Subject: Circulation Comments, 4840 Bank Street

The following **COMPLETE** comments are provided in response to the submission received by the City on June 7, 2022 and as an update to the partial comment letter dated July 27, 2022.

- A Site Plan Control application has been submitted to construct three, four-storey low rise apartment buildings, each with 60 units for a total of 180 dwelling units with a total gross floor area of 17,466.9m² and surface parking.

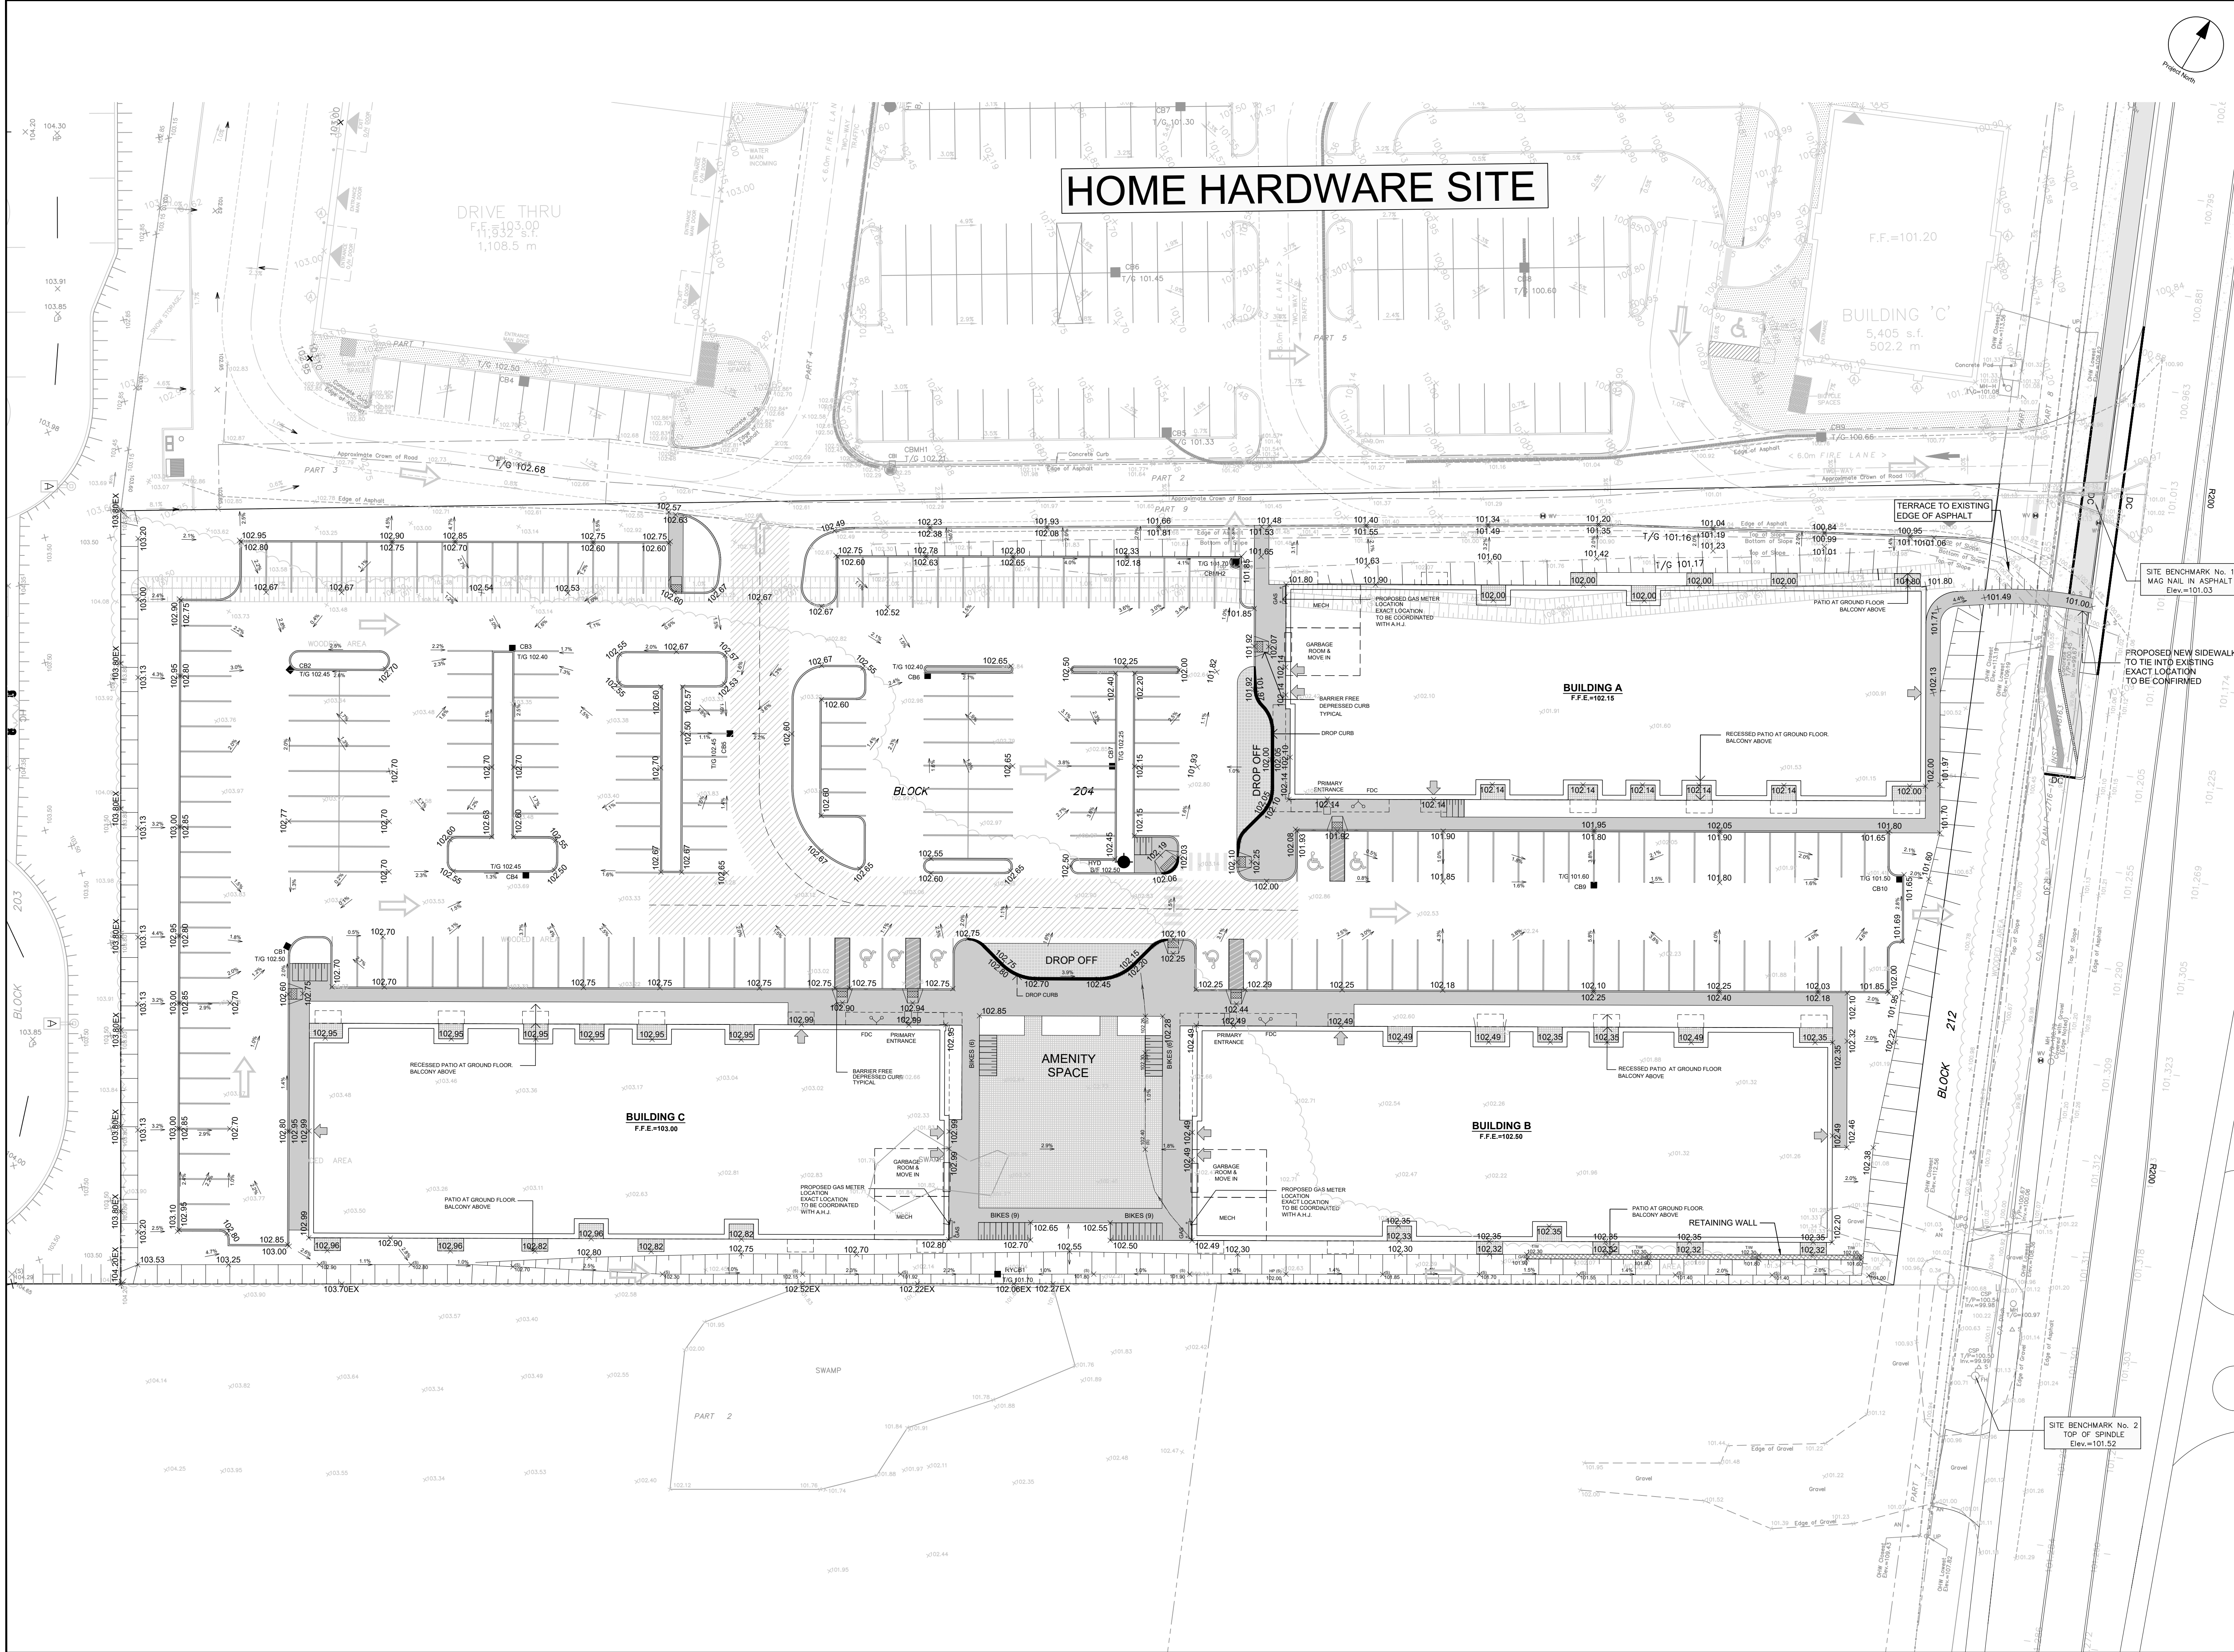
- A1. Clearly identify the location of the proposed firewalls to support the provided FUS calculations.
- A2. Subdrains are required for swales with slopes less than 1.5%.
- A3. Provide ICD locations and restricted flow rates on the plan.
- A4. Roofdrain locations are required on the plan.

SHEET TITLE
PONDING PLAN

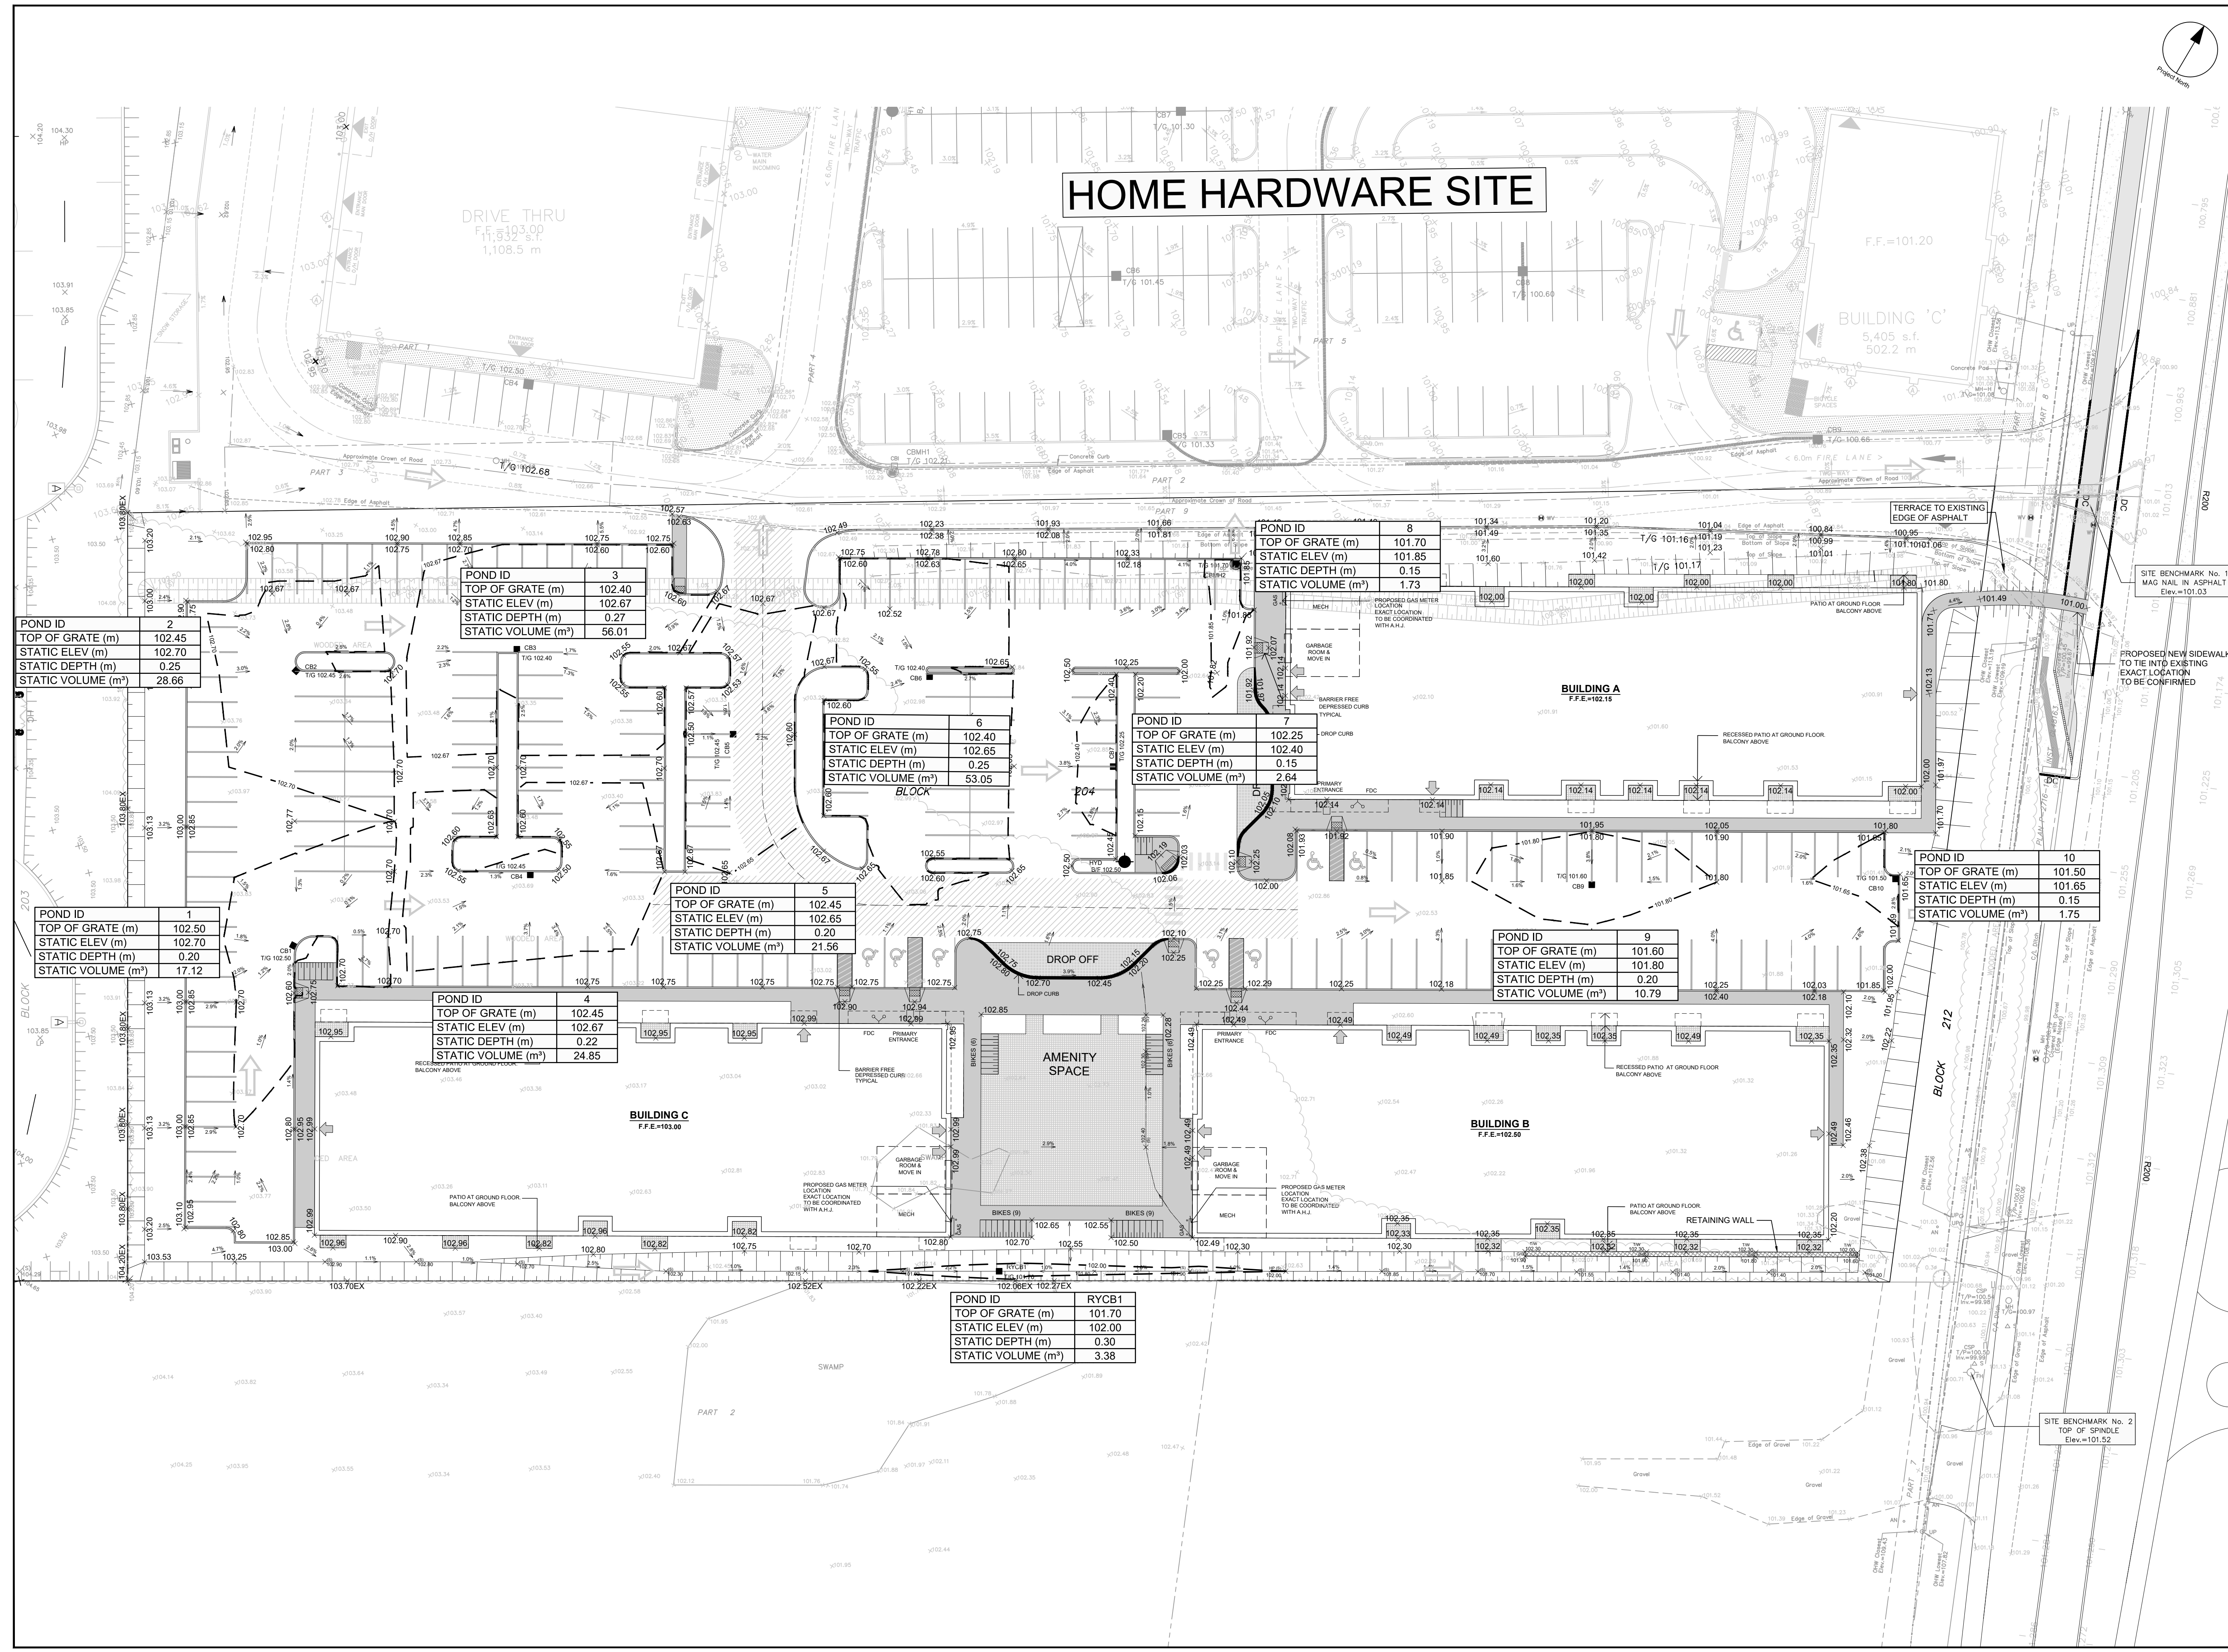
A14. Where rooftop storage is provided, the following information should be provided on the design drawings:

1. Rooftop storage volume
2. Depth of flow
3. Location of roof drains
4. Number of roof drains
5. Flow per roof drains
6. Total flow from roof

A15. Provide the 5-year, 100-year and stress test (if different from 100-yr) event ponding limits on the plan.
